CITY OF ALBUQUERQUE

February 17, 2017

RE: Arroyo Vista Apartments
Grading and Drainage Plan
Engineer's Stamp Date 2-6-2017 (File: G16D153)

C-101

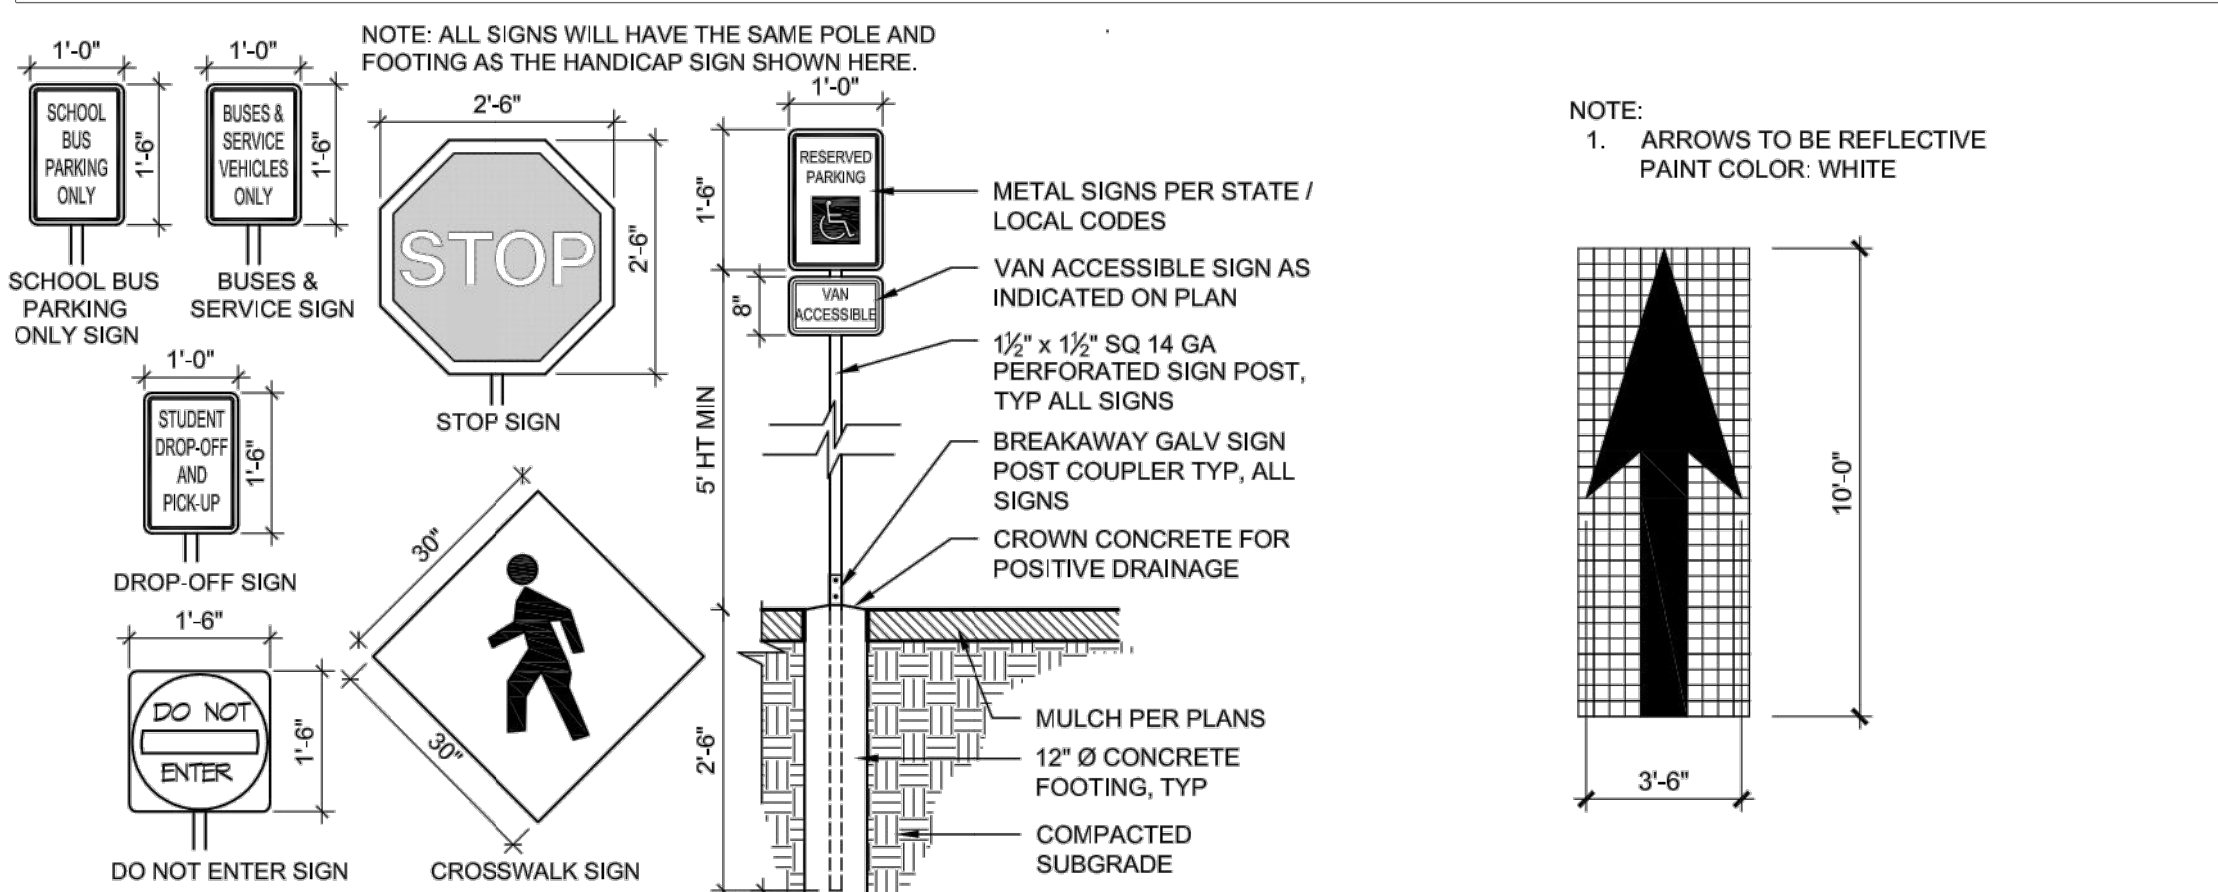
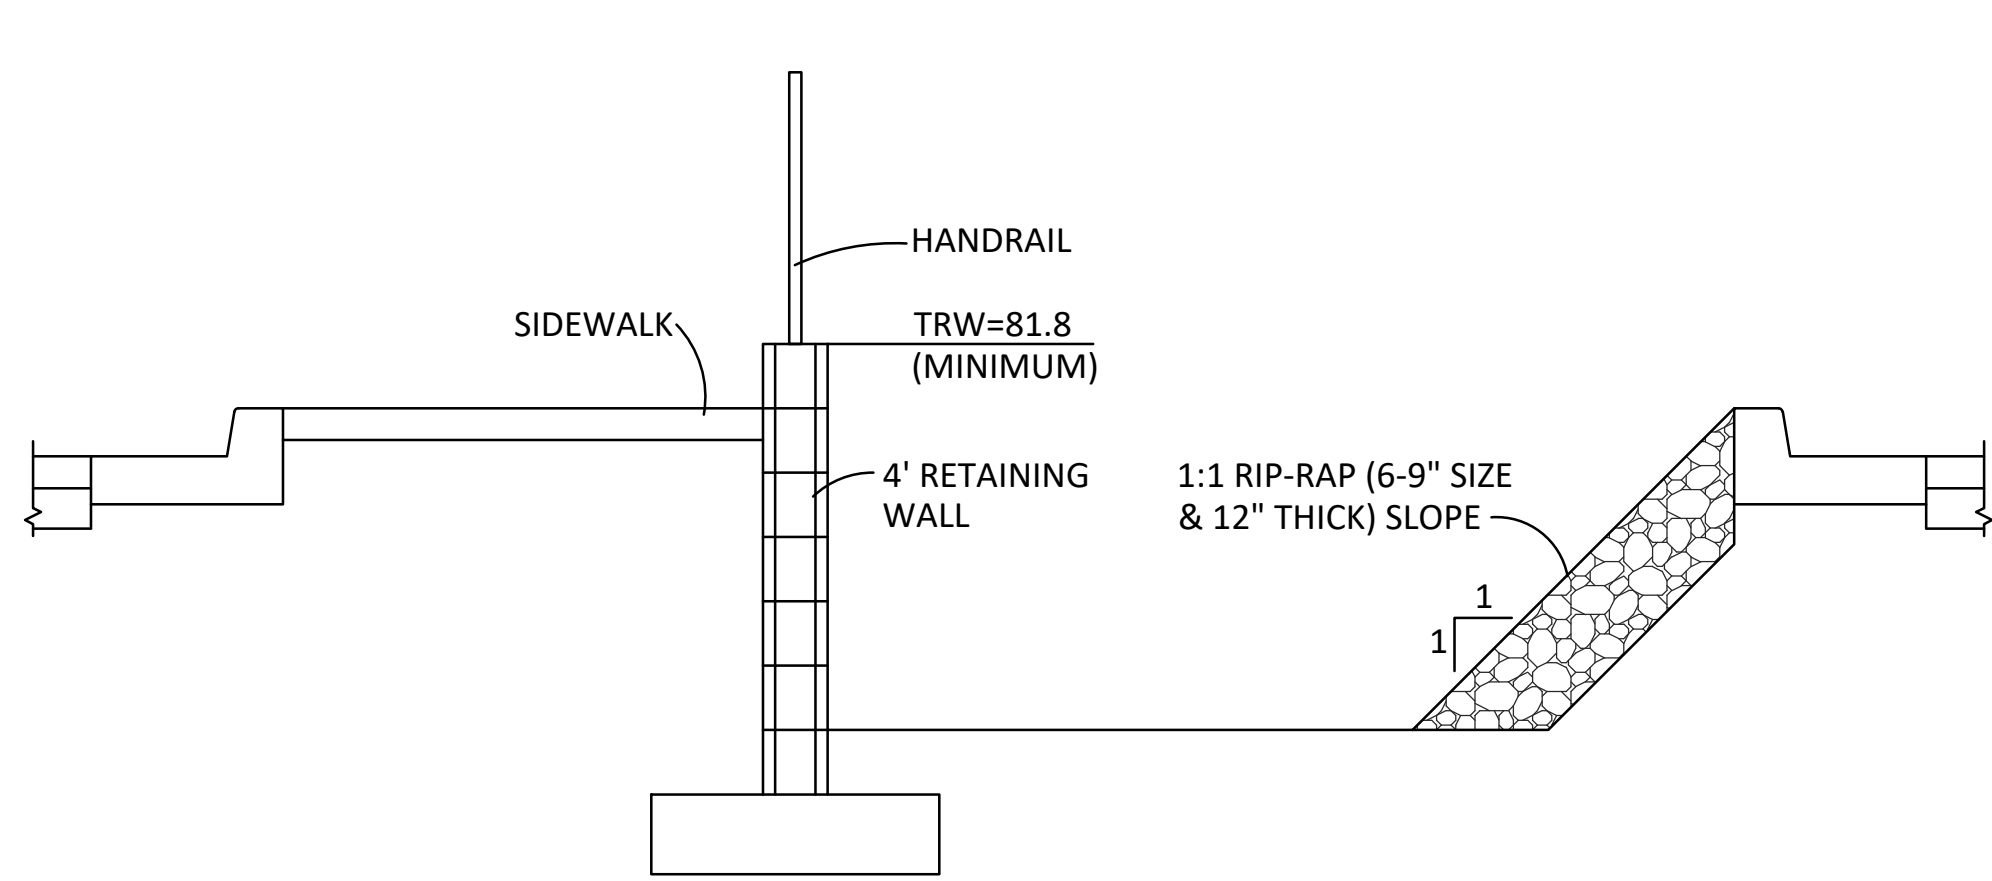
1. AMAFCA approval is required.
2. Hydraulic calculations for the onsite storm drain is required.
3. Stand the pipe or elevate grate for storm drain on the west side of the site. How is the first flush pond volume being accomplished?

4. Provide first flush volume calculations for individual ponds.
5. It's seems there is an offsite flow from the northeast side of the site. Provide a narrative for this offsite flow, is this part of the 1.75 AC offsite area? Was the impervious area assumed in calculation?

6. Who will maintain the retaining wall on the northeast side outside project? Do you have construction easement?
7. Provide document on the city project 595281 which allows 50.6 cfs discharge.

8. Provide onsite sub basin and show how much runoff is being routed to the sidewalk culvert at the southwest corner of the project. Include side walk culvert capacity calculations.

9. Are you allowed to drain to access road to the west? Is there adequate capacity via surface? and downstream storm drainage system? Do you have access and drainage easement across adjacent property?

10. Show the property line more clearly. Show full extend of the project on this plan.
11. Erosion and sediment control plan must be approved prior to building permit approval.
